DECISION DELEGATED TO DEVELOPMENT MANAGER

Application No: H20-0289-20 **Applicant:** Mr M Campling
Proposal: Proposed Boundary Fence (retrospective)
Location: The Yews 2 Jarvis Gate Sutton St James
Terminal Date: 1st July 2020

LOCATION & SITE PLANS.

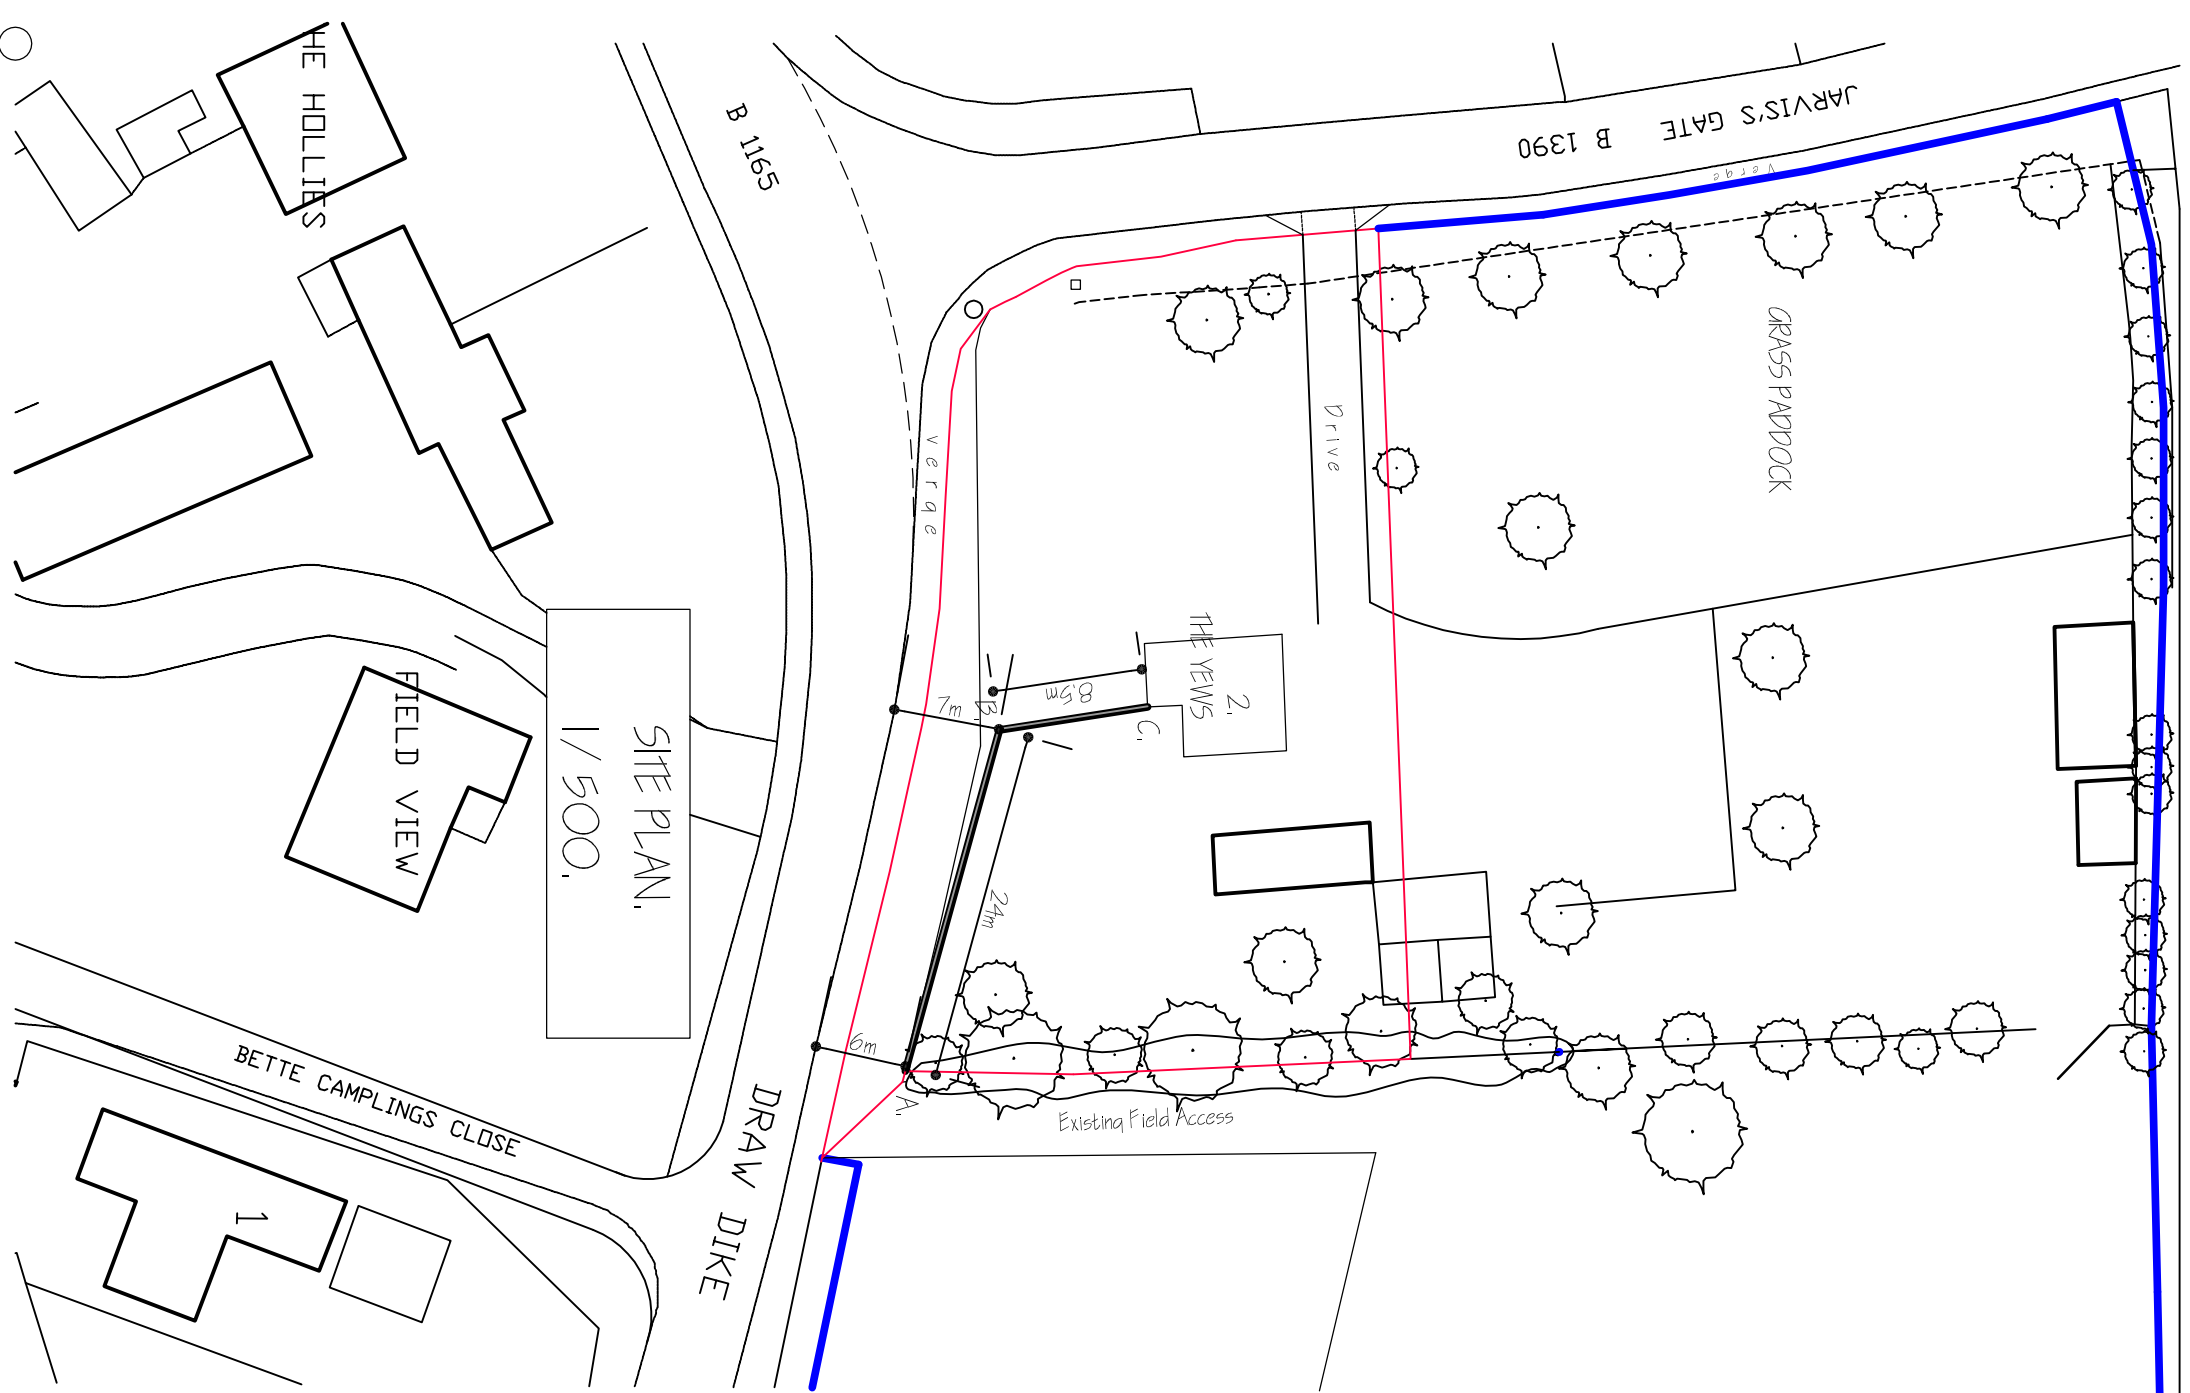
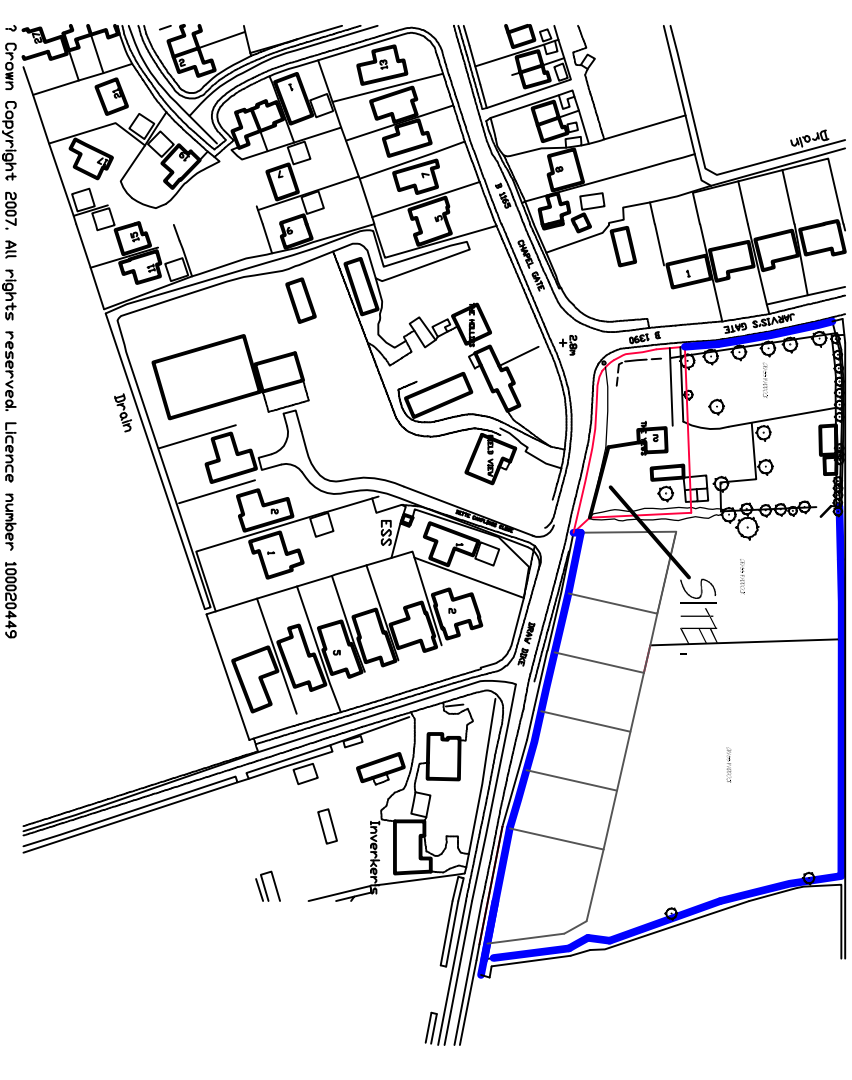
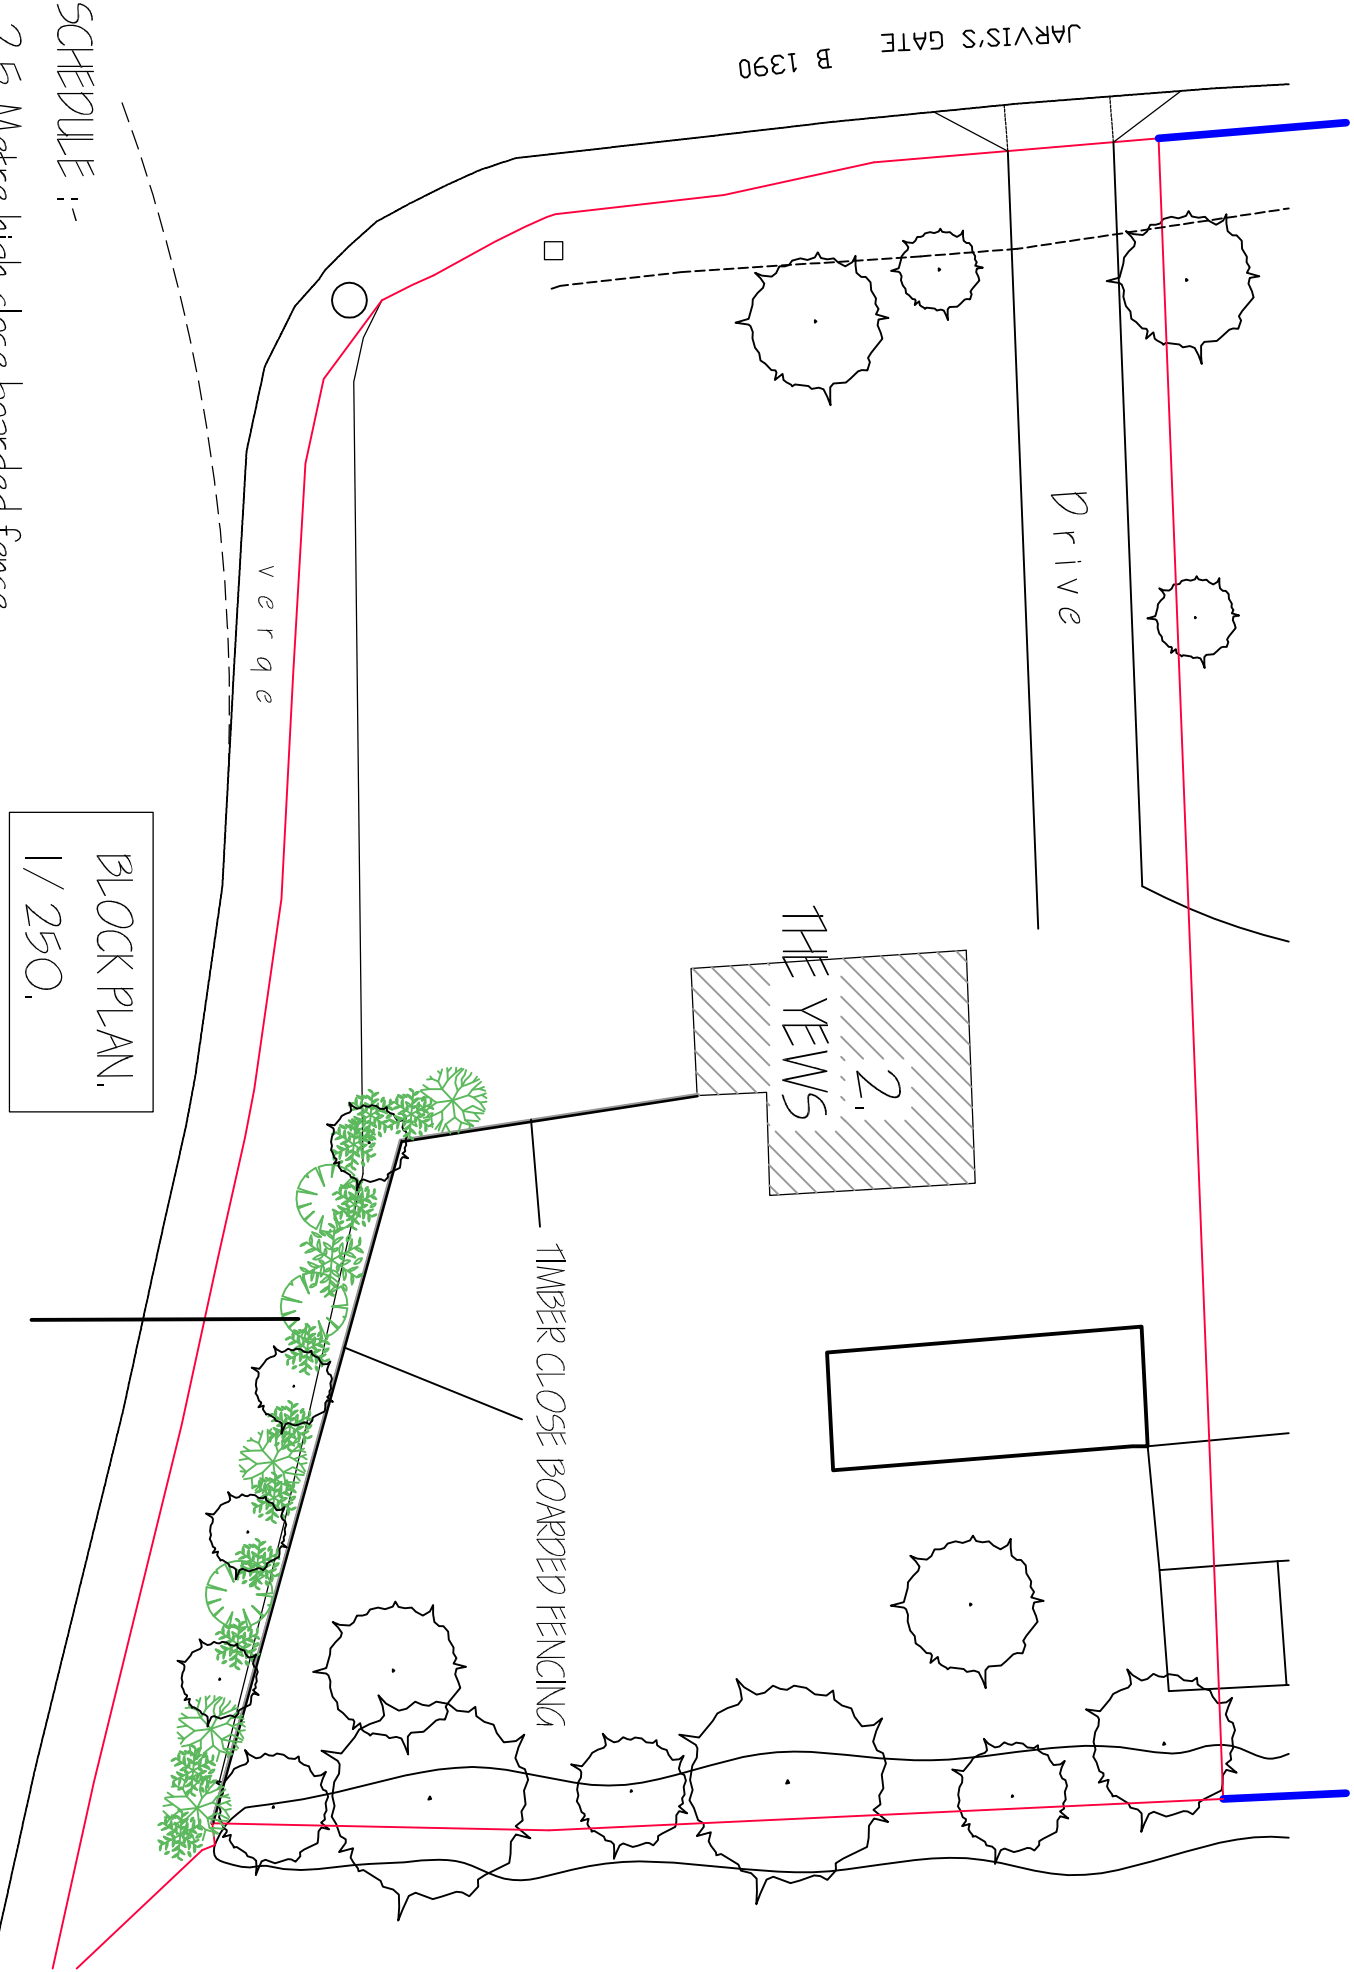
The proposed fencing extends from the side wall of the house (point C on the block plan) to the southern boundary (point B) and further towards the rear boundary (point A). The first section (point A-B) measures 2 metres in height whereas the remainder facing Sutton Gate (point B-C) is 2.5 metres high. The purpose of the fence is to obscure further the views from the roads onto the rear garden of the dwelling.

The section running in parallel with the southern boundary is set back between 7 and 6 metres from the edge of the carriageway. In conjunction with the low topography of the site as mentioned above, the visual impact of the fence is slightly reduced upon the wider street scene. Moreover, the fence is not excessively long given the size of the entire plot and it is located at one of the least prominent locations of the boundary adjoining the highways. Last but not least, the proposals also include new planting and hedging which will help mitigate the presence of the fence and soften its visual impact.

Having regard to the considerations above, and the fact that the applicant could have erected a 2m high fence between points B-C without the need for planning permission, it is considered on balance that there is not sufficient justification for a refusal and that the development accords with the
